From: Contact Centre (CRM) <contact@ribblevalley.gov.uk>
Sent: 20 November 2023 12:04
To: Planning
Subject: Planning Application Comments - 3/2023/0866 FS-Case-563321067

Planning Application Reference No.: 3/2023/0866

Address of Development: 11 Old Road Chatburn

Drawing Title
Sections

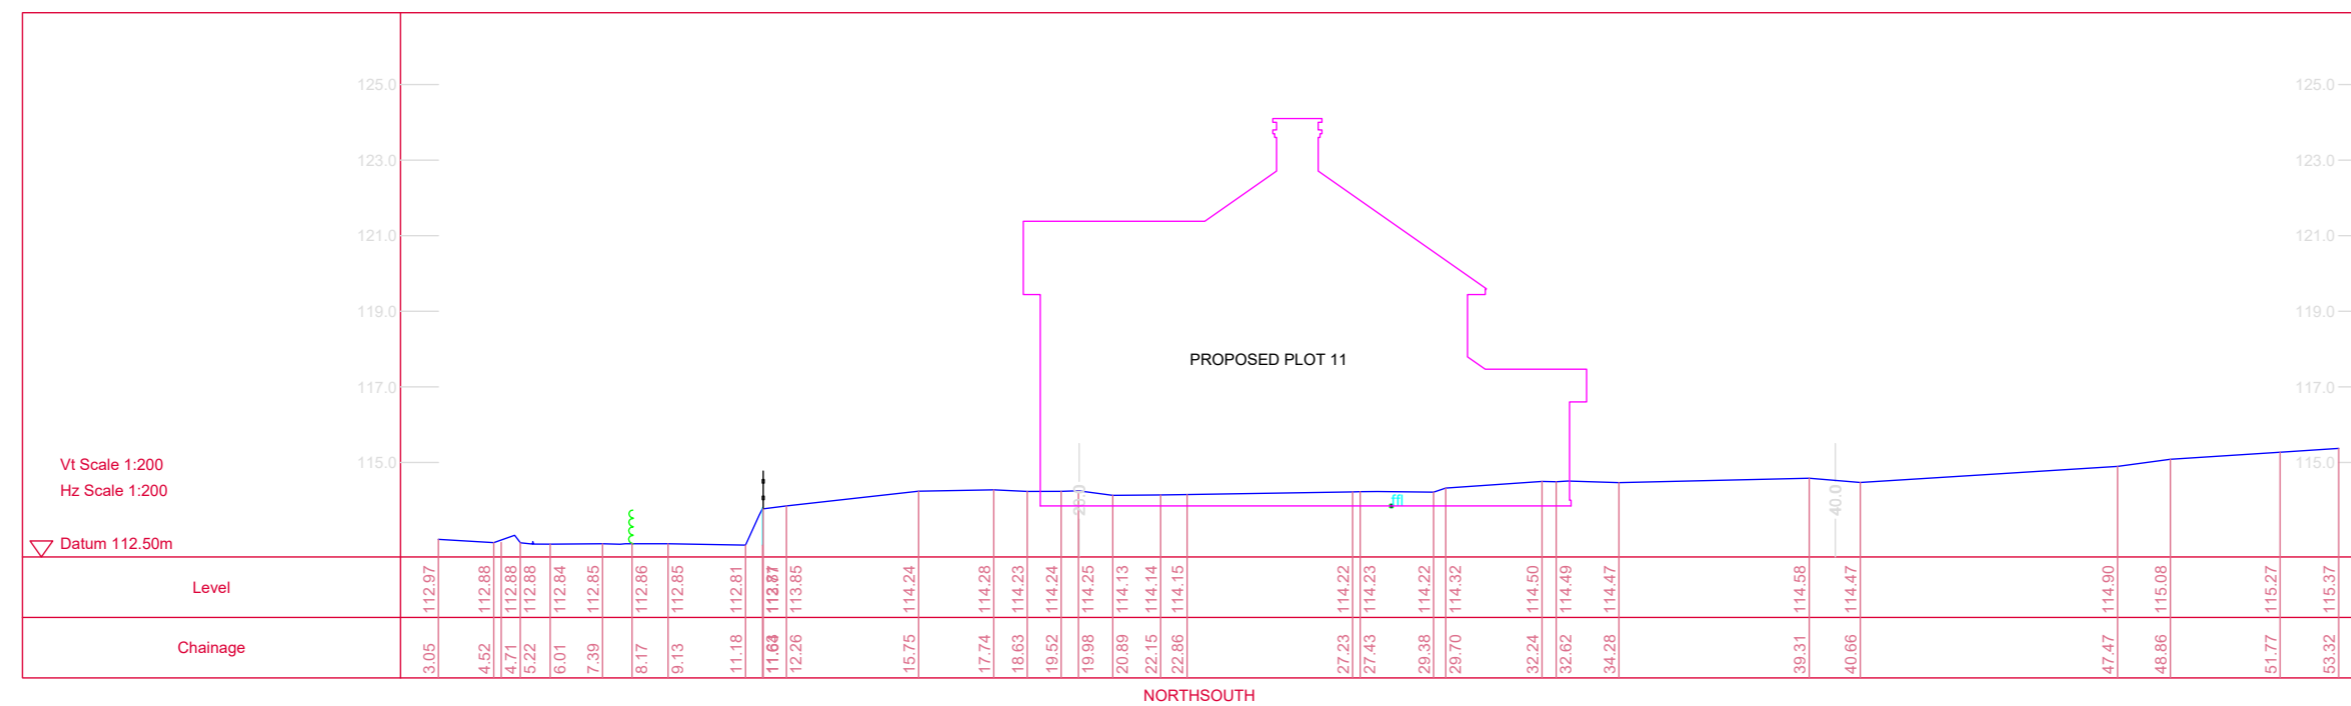
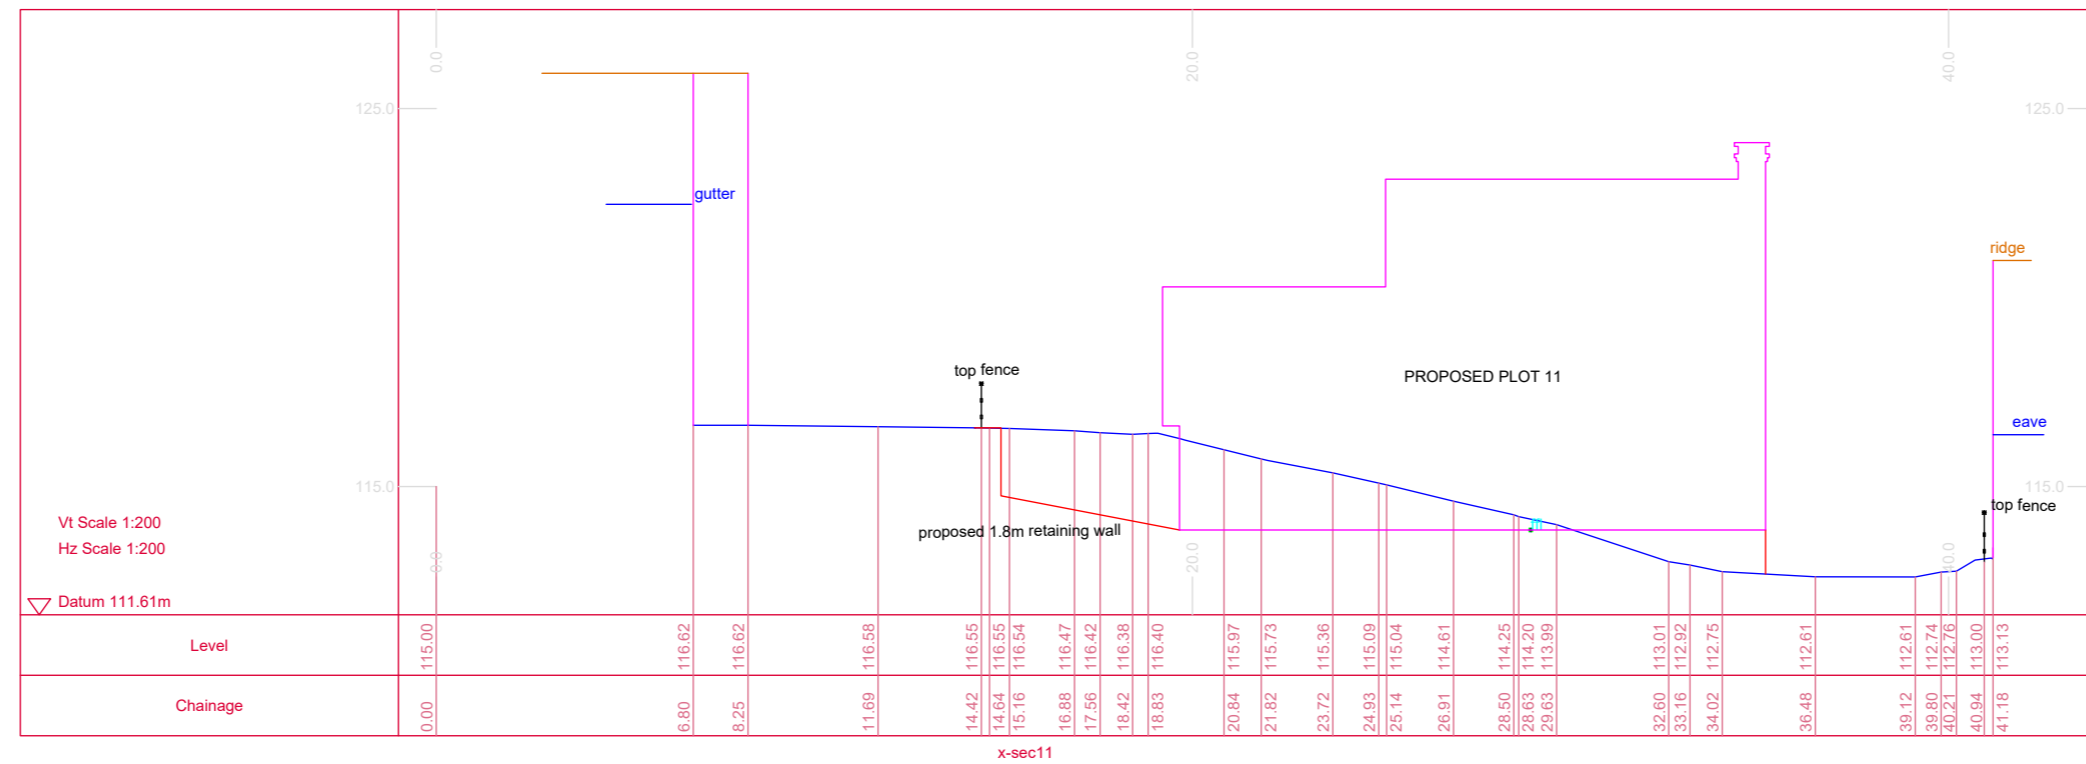
Comments: This new application is very lacking in any detail, with no sections through the elevations. It does not show any details on how number 1-2 Harehill croft are retained, nor any detail on the ground work adjacent to 9 old Road. Please can we request further and better details on the building levels in respect to Old Road, which is on a significant slope. The current drawing seen to show the front elevation sitting on level ground, which cannot be. Also the ground plan is inaccurate in the boundary between the development and 1-2 Harehill Croft. No 2 HHC protrudes into the land by 1-1.5 meters in comparison to No 1 and 3.
